September 26, 2023

RE: **SHL23-025 & SEP23-010** SUB2 Review Letter; 4452 Ferncroft Rd, Mercer Island, WA 98040

DESCRIPTION OF WORK

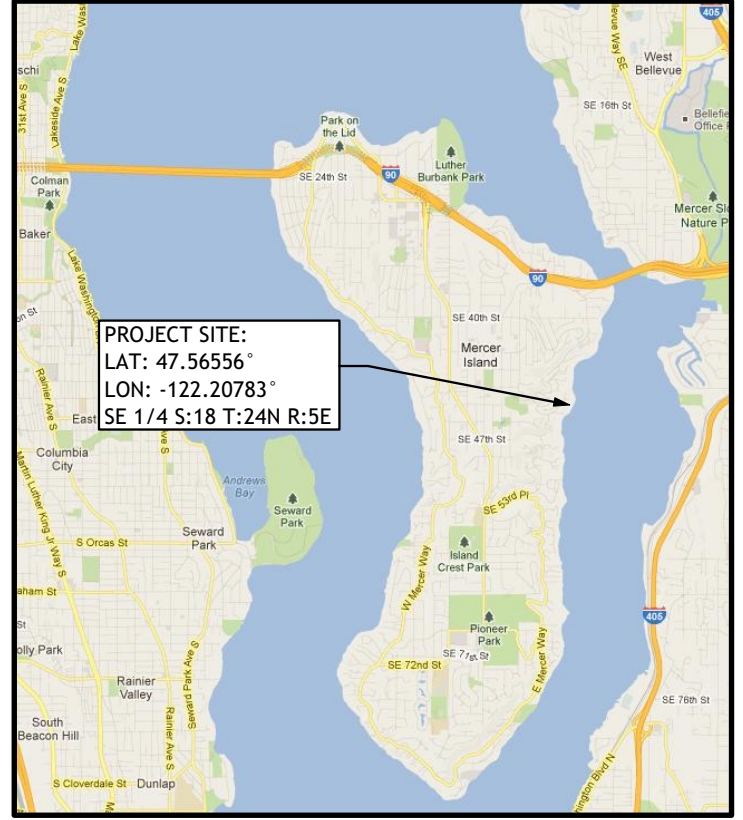
1. All application materials must accurately reflect the scope of work. The project narrative submitted with the original materials describes portions of the project that will be permitted under separate permits by the adjacent property. Please revise all application materials to accurately reflect the proposed development.
2. No Action Necessary – The Shoreline Substantial Development Permit and associated building permit will contain the following Conditional of Approval:
 - a. Prior to final inspection of the development activities authorized in this permit, the portions of the existing dock that encroach over the lateral line from the adjacent property at 4456 Ferncroft Road must be removed in their entirety.
